CITY OF ALBUQUERQUE

**RE: State Employees Federal Credit Union
Grading and Drainage Plan
Engineer's Stamp Date 10-19-16 (File: F16D001)**

ENGINEER'S SEAL DAVID SOULE 10-19-16	STATE EMPLOYEE FEDERAL CREDIT UNION GRADING AND DRAINAGE PLAN Rio Grande Engineering 1606 CENTRAL AVENUE SE SUITE 201 ALBUQUERQUE, NM 87106 (505) 872-0999	DRAWN BY WCWJ DATE 10-19-16 21628-LAYOUT-8-28-16 SHEET # 4 JOB # 21628
--	---	--

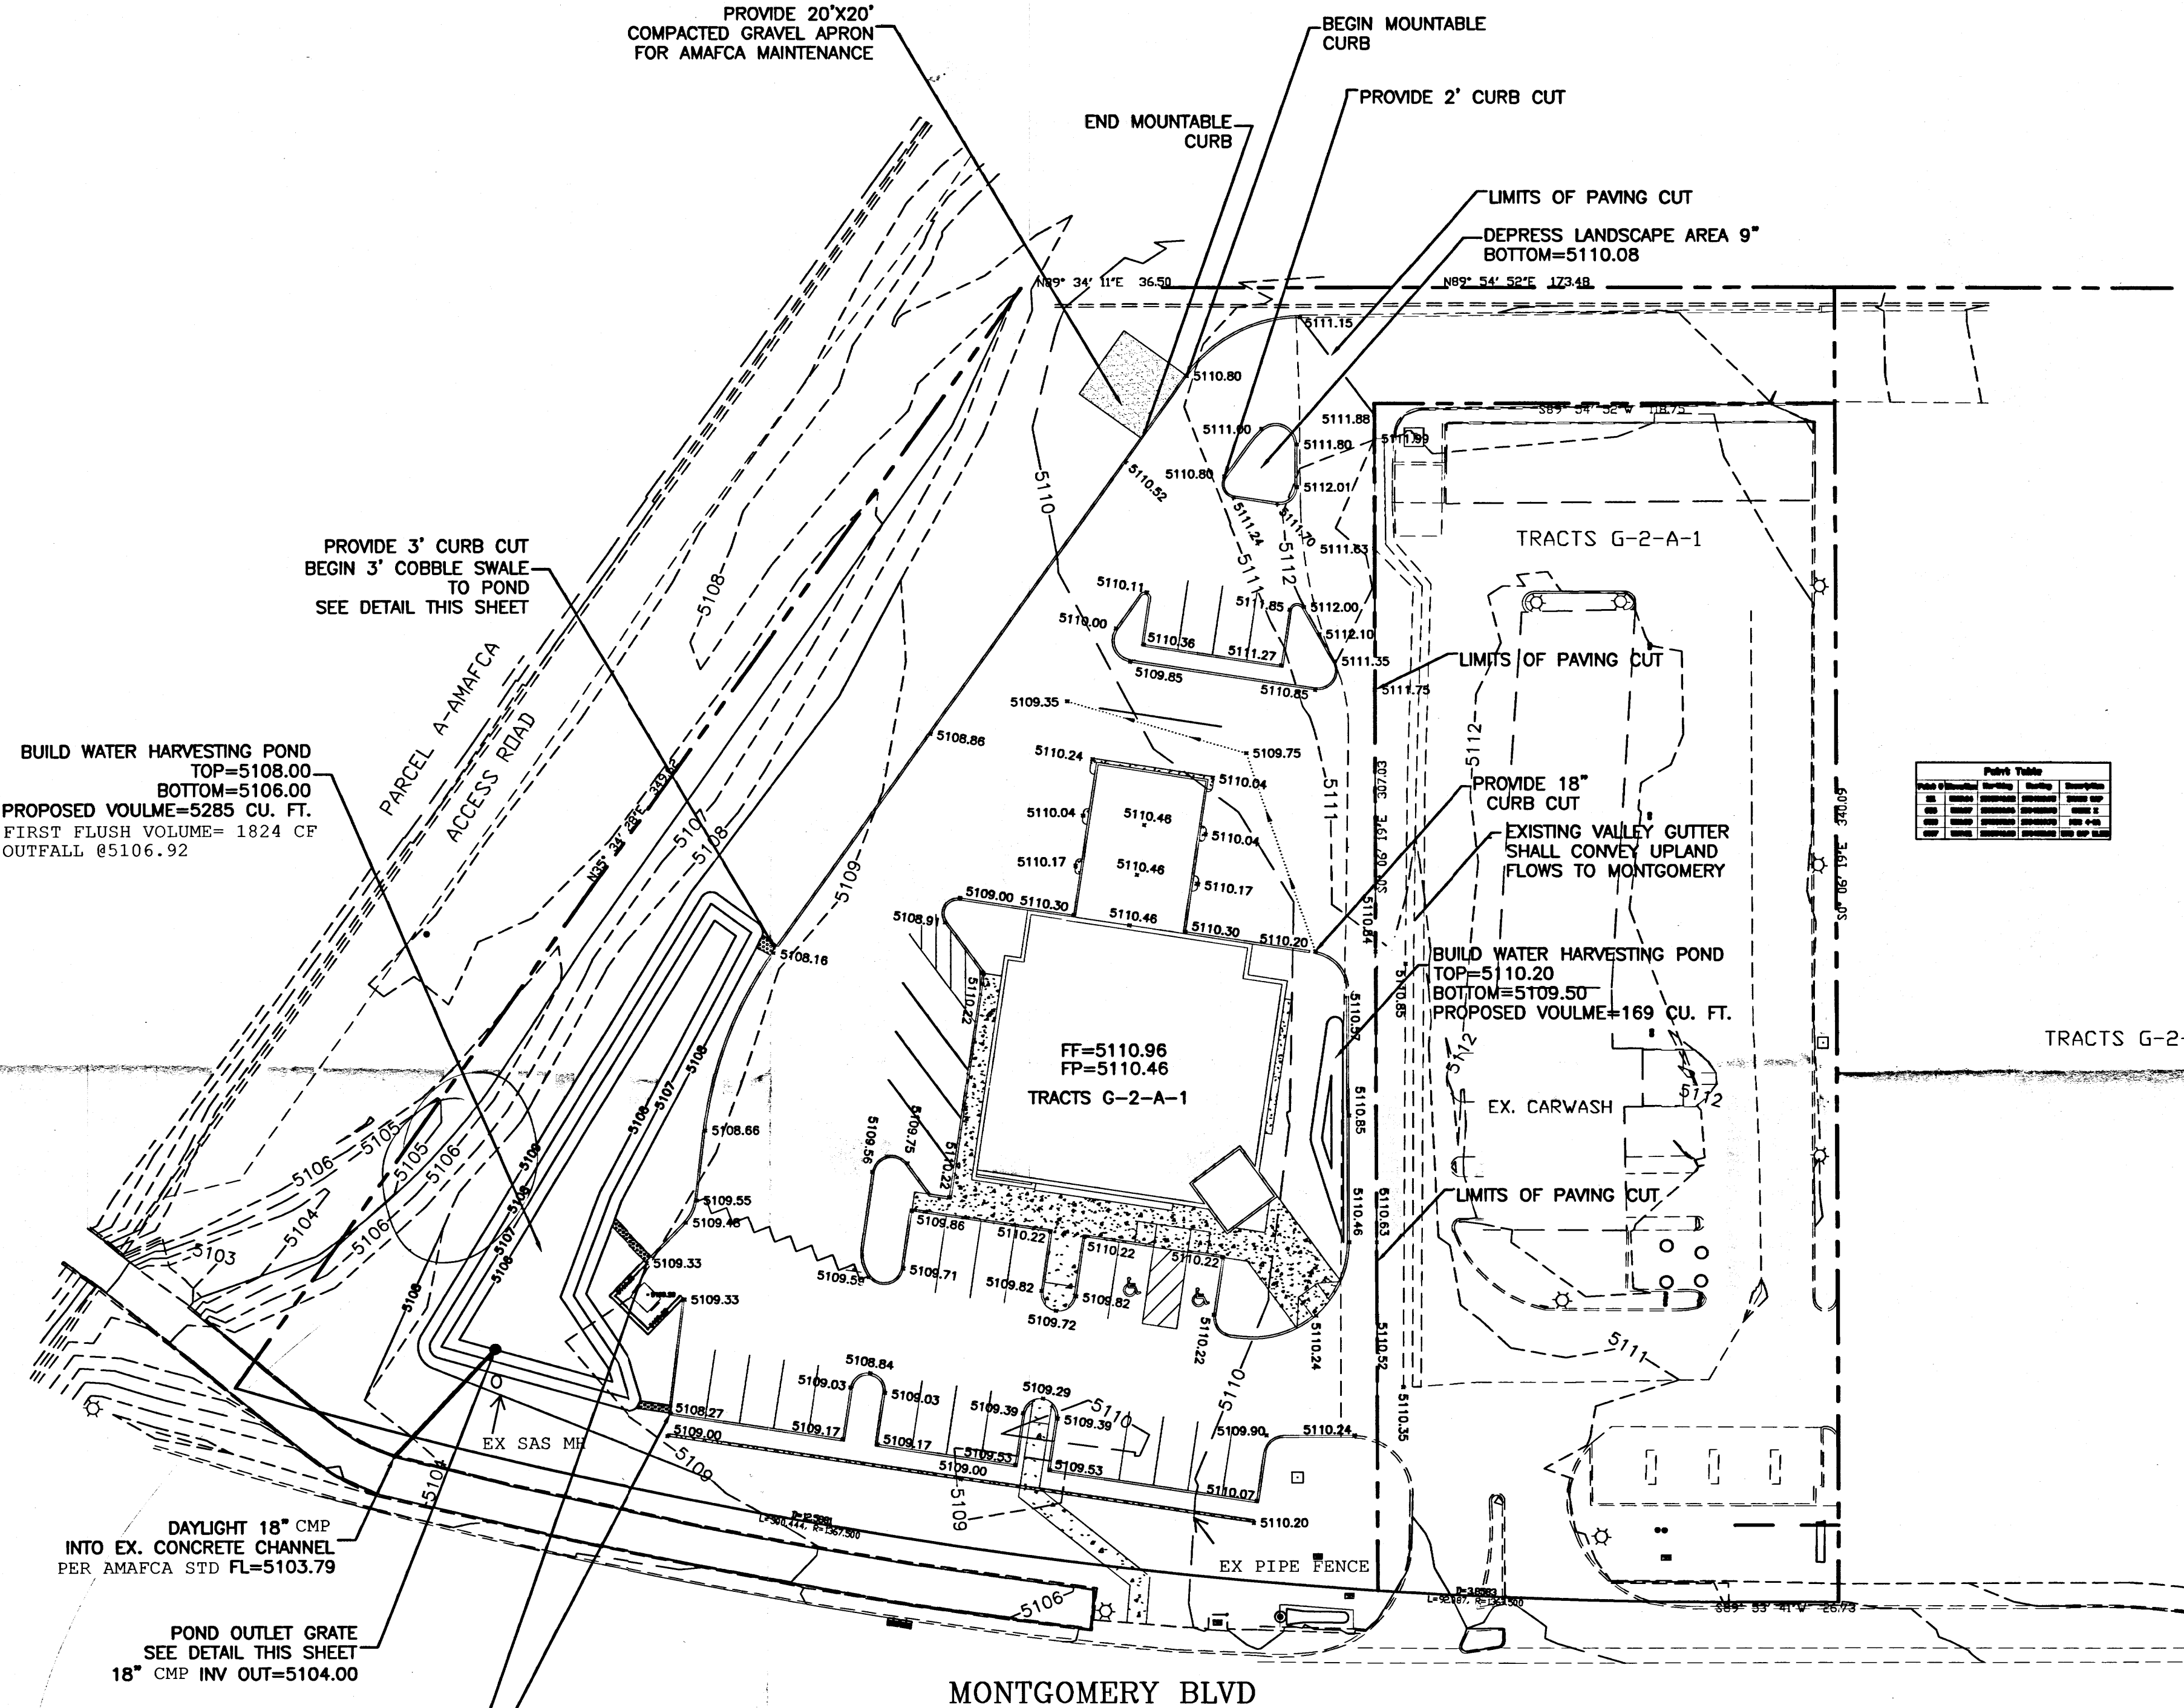
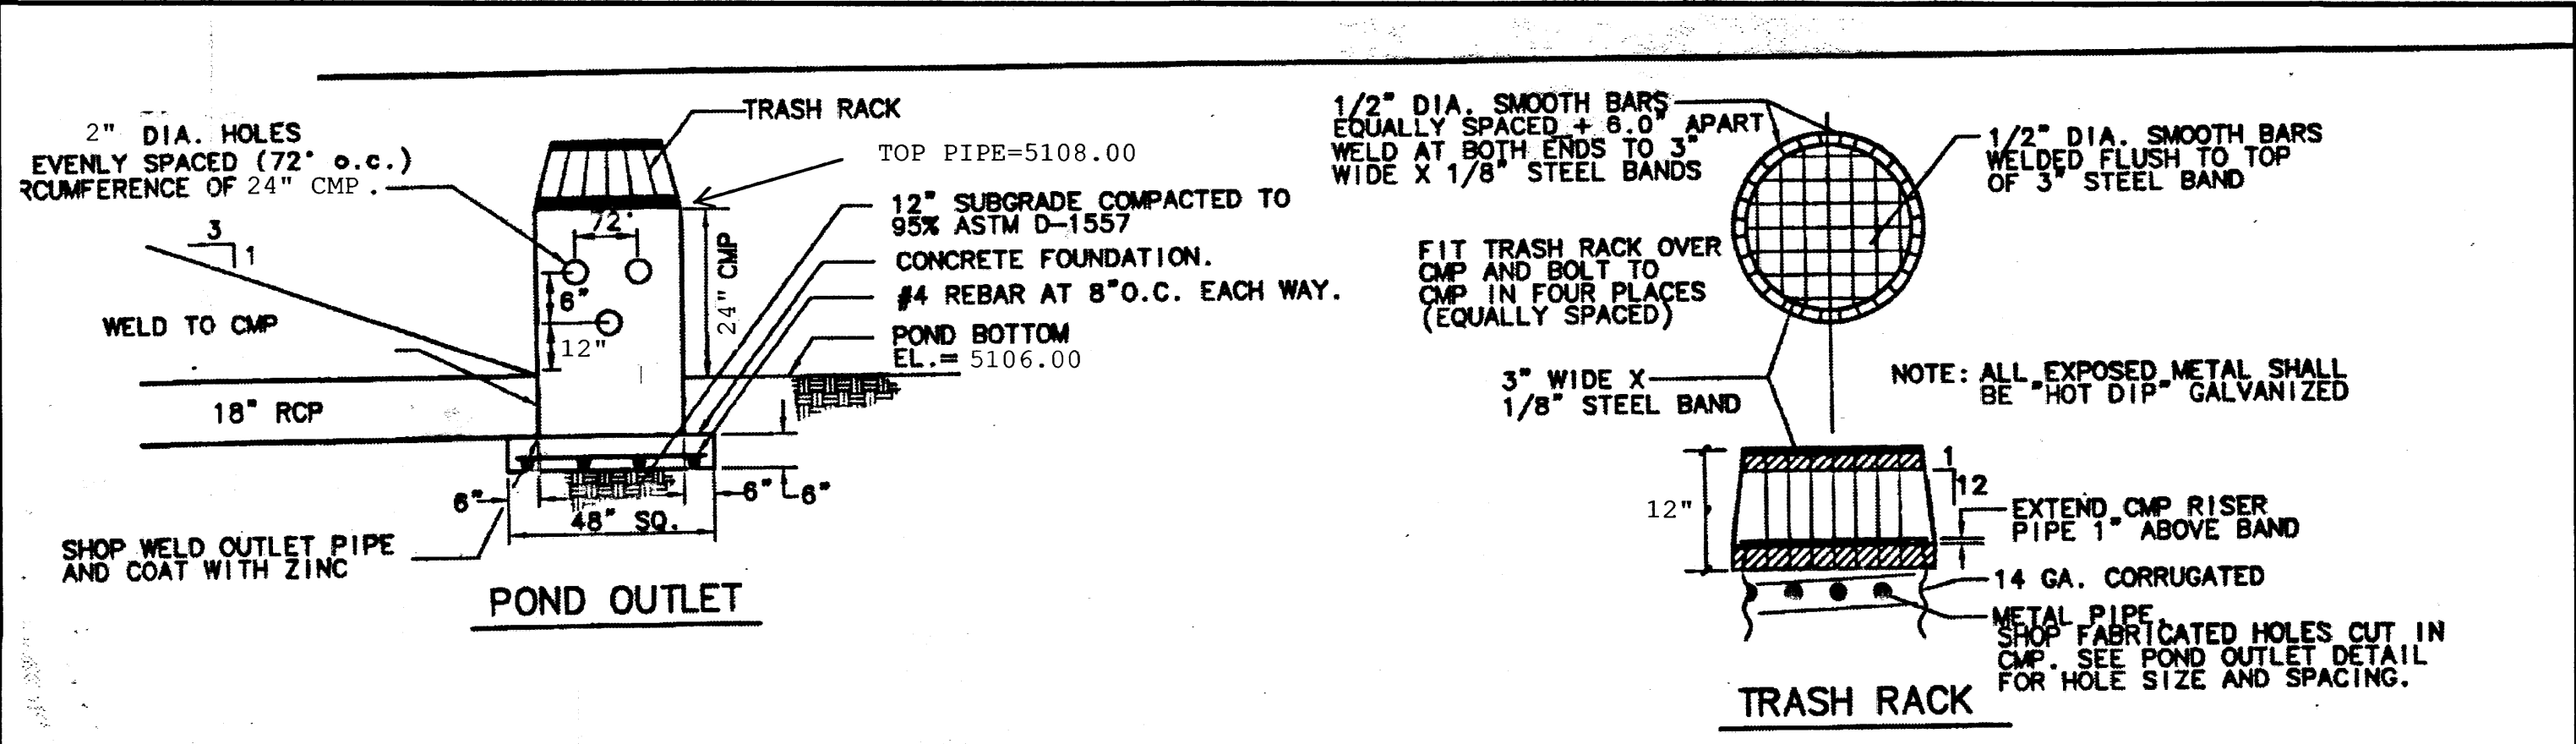
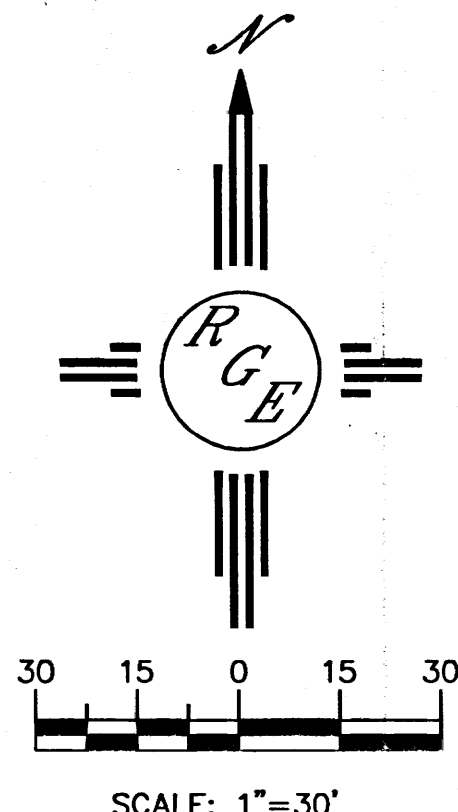
1. The comments from AMAFCA regarding the outfall from the pond into and within their property will be approved through a turnkey agreement. The constructed improvements will need to be approved prior to approval for Occupancy.
